CASTLE GROUP

SSD-9472 Sikh Grammar School
Lots 42 & 43 DP30186 151-161 Tallawong Road Rouse Hill

The following forms our submission regarding the above Development Application for a proposed school. We are making a submission on behalf of the adjoining site to the north at 141 Tallawong Road Rouse Hill, in addition to 95 Tallawong Road, 114 Tallawong Road, 105 Cudgegong Road and 119 Cudgegong Road as well as the Rouse Hill Residents Action Group

DRAWING TITLE
DRAINAGE PLAN (STAGE 1)

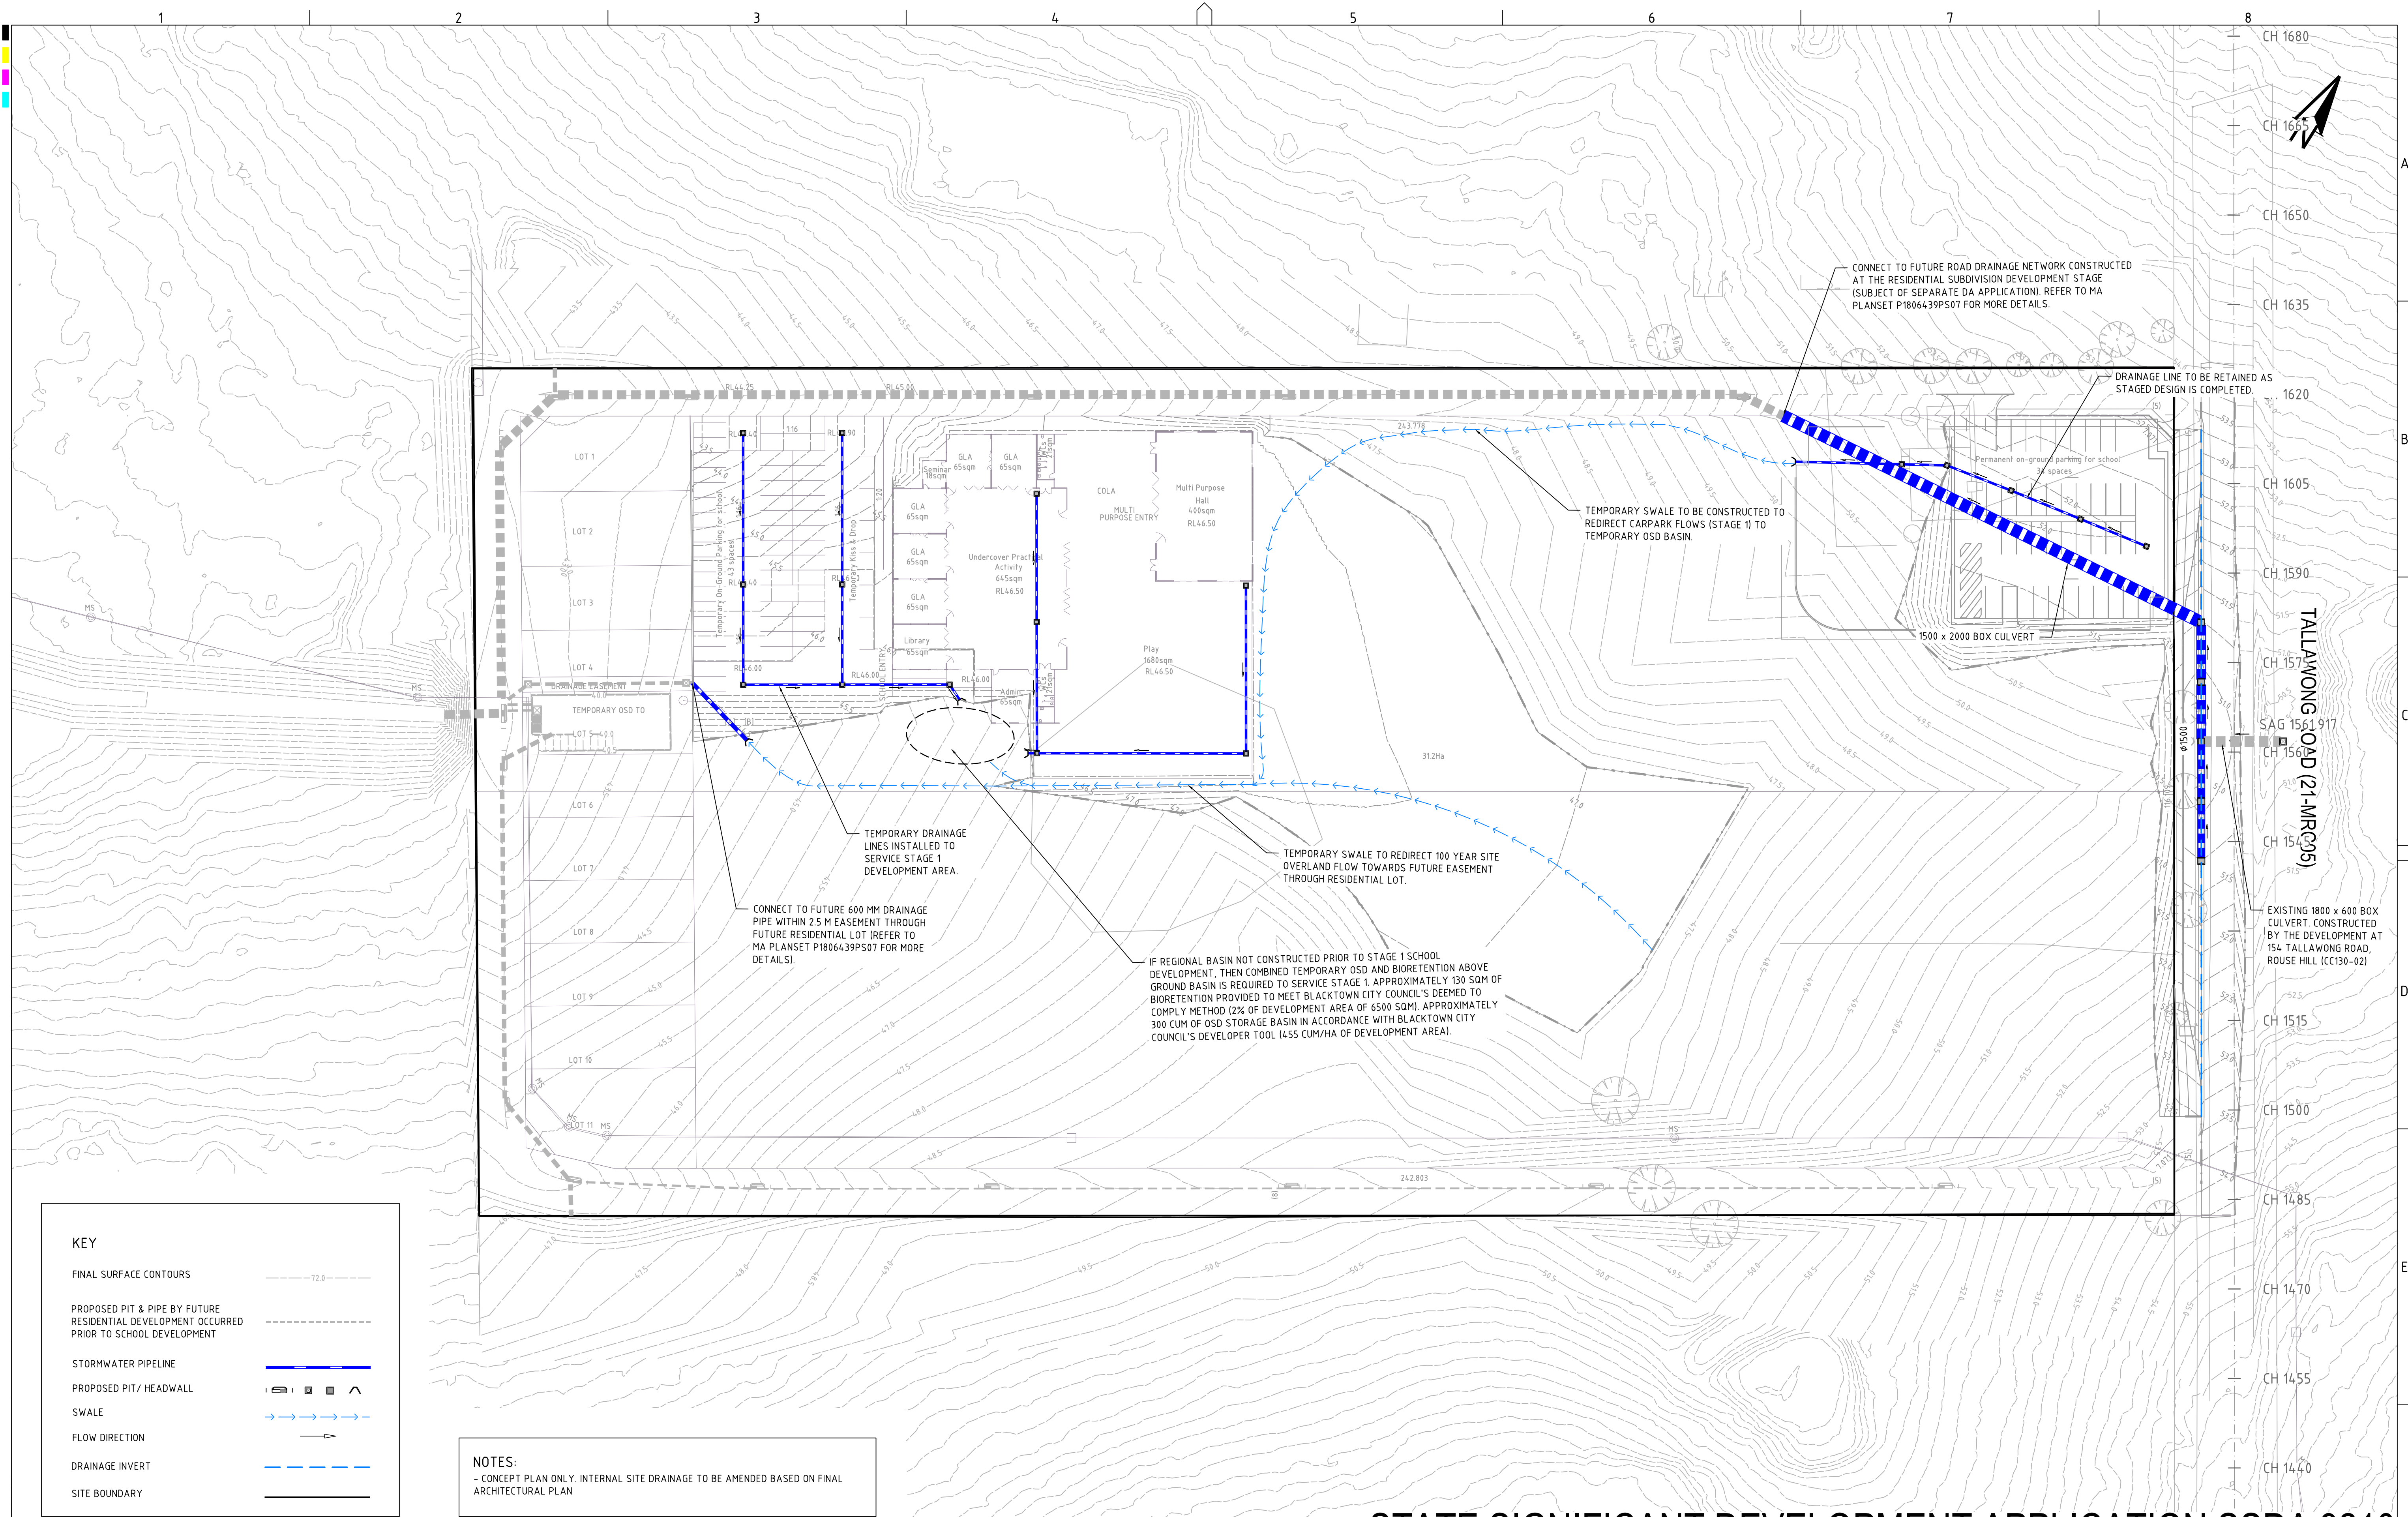
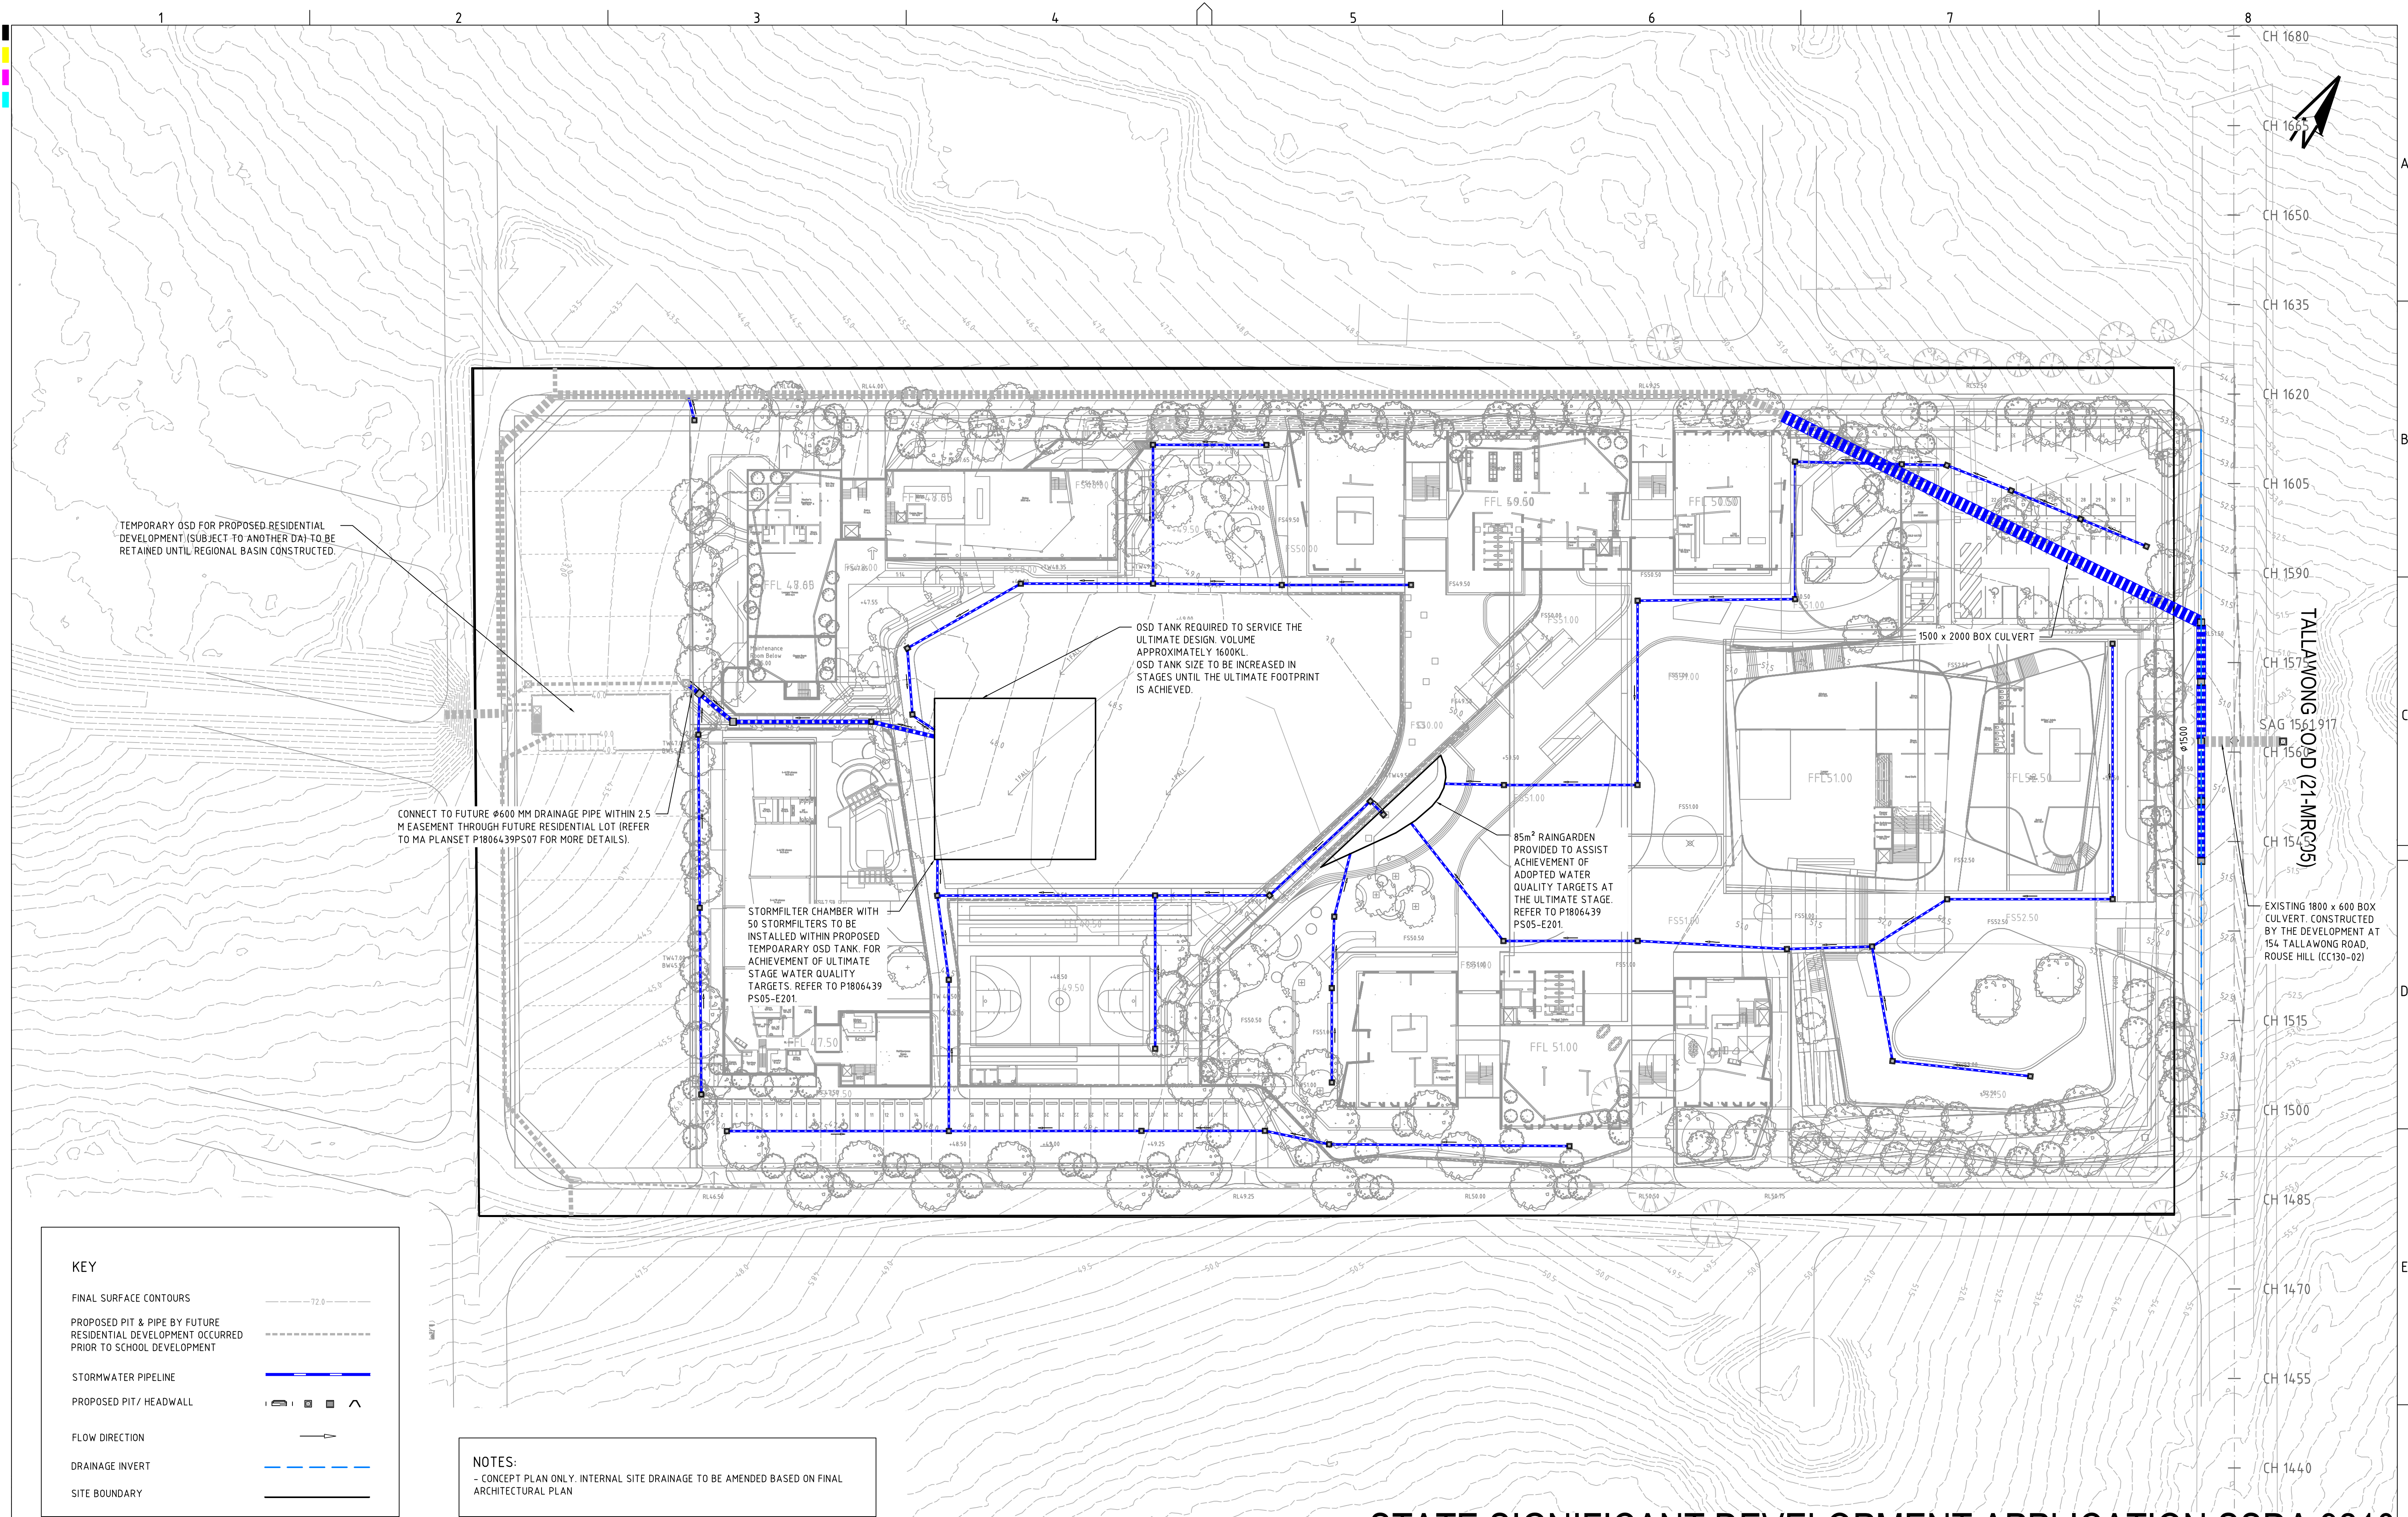
The site is identified as flood prone land. It is understood that flood mitigation works will create a flood free site for development by diverting water to the proposed northern half road. Confirmation is sought that this water will not enter our property (141 Tallawong Road) as a result of the road construction not being completed as a component of this development.
